**CITY OF PORTLAND, MAINE
DEVELOPMENT REVIEW APPLICATION
PLANNING DEPARTMENT PROCESSING FORM
DRC Copy**

38 Heather Road

Project Name/Description

REVISION: 08-23-03~ REVISED SIDE SETBACK, MOVED HOUSE, ADDED 4'X8' LANDING, MOVED BULKHEAD.
MINOR SITE PLAN
 34-40 HEATHER ROAD PORTLAND, MAINE
 FOR: **JAMES & MARY BEALE**

<b>MINOR SITE PLAN</b> 34-40 HEATHER ROAD PORTLAND, MAINE	
FOR:	
<b>JAMES &amp; MARY BEALE</b>

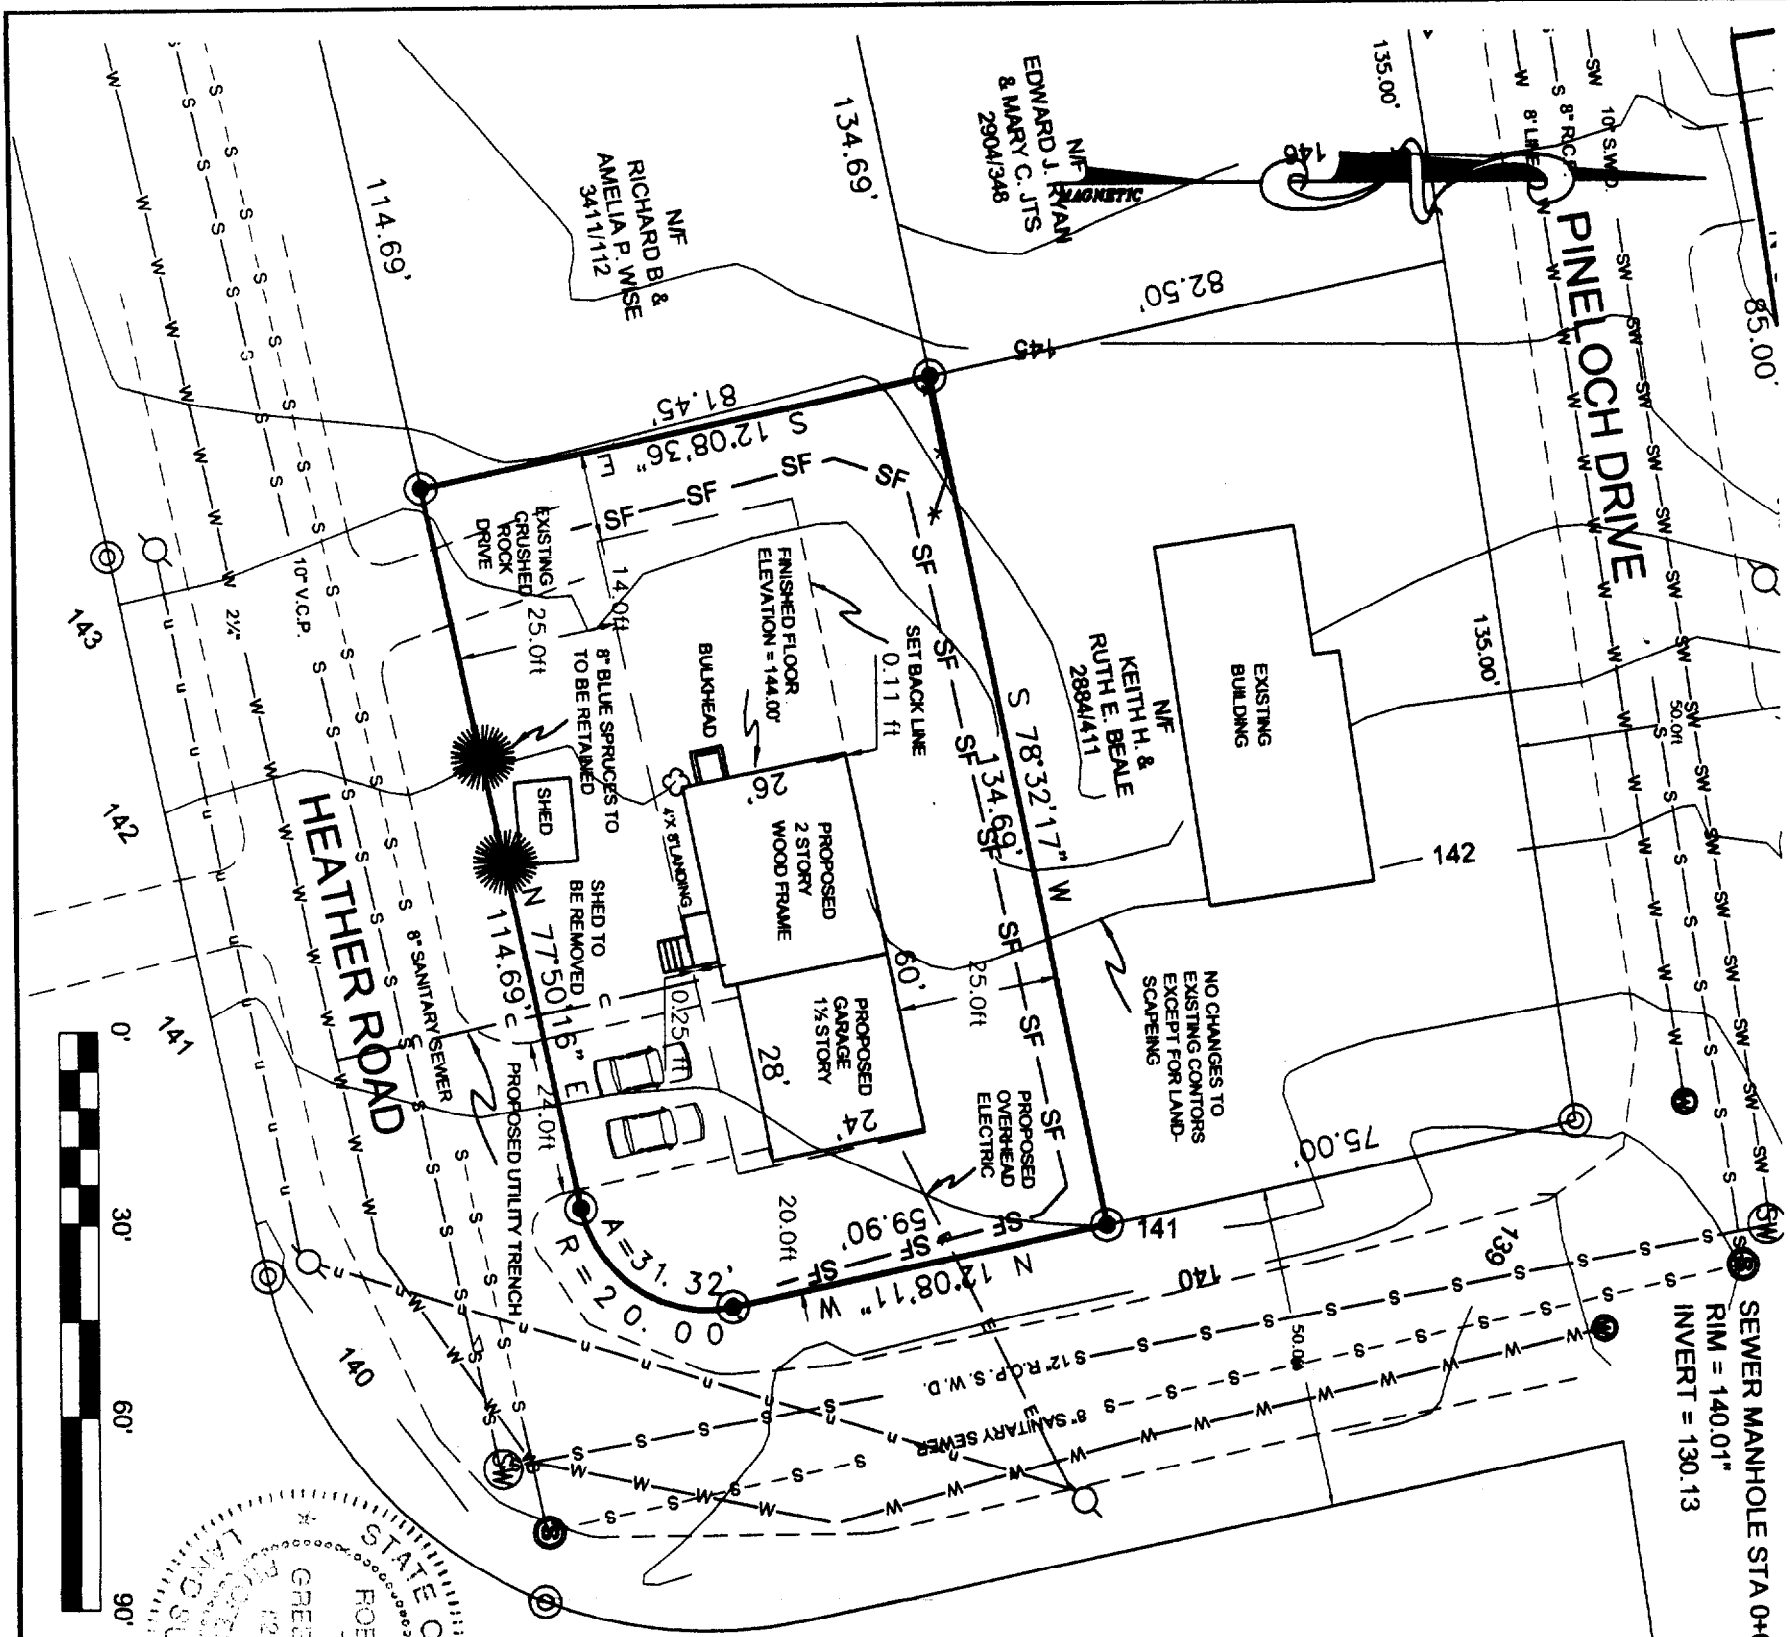
Marge,
Please accept the attached plans for your use. As you pointed out the side setback on a side street is 20 feet in this zone. I revised the location of the house to reflect the accurate setback.
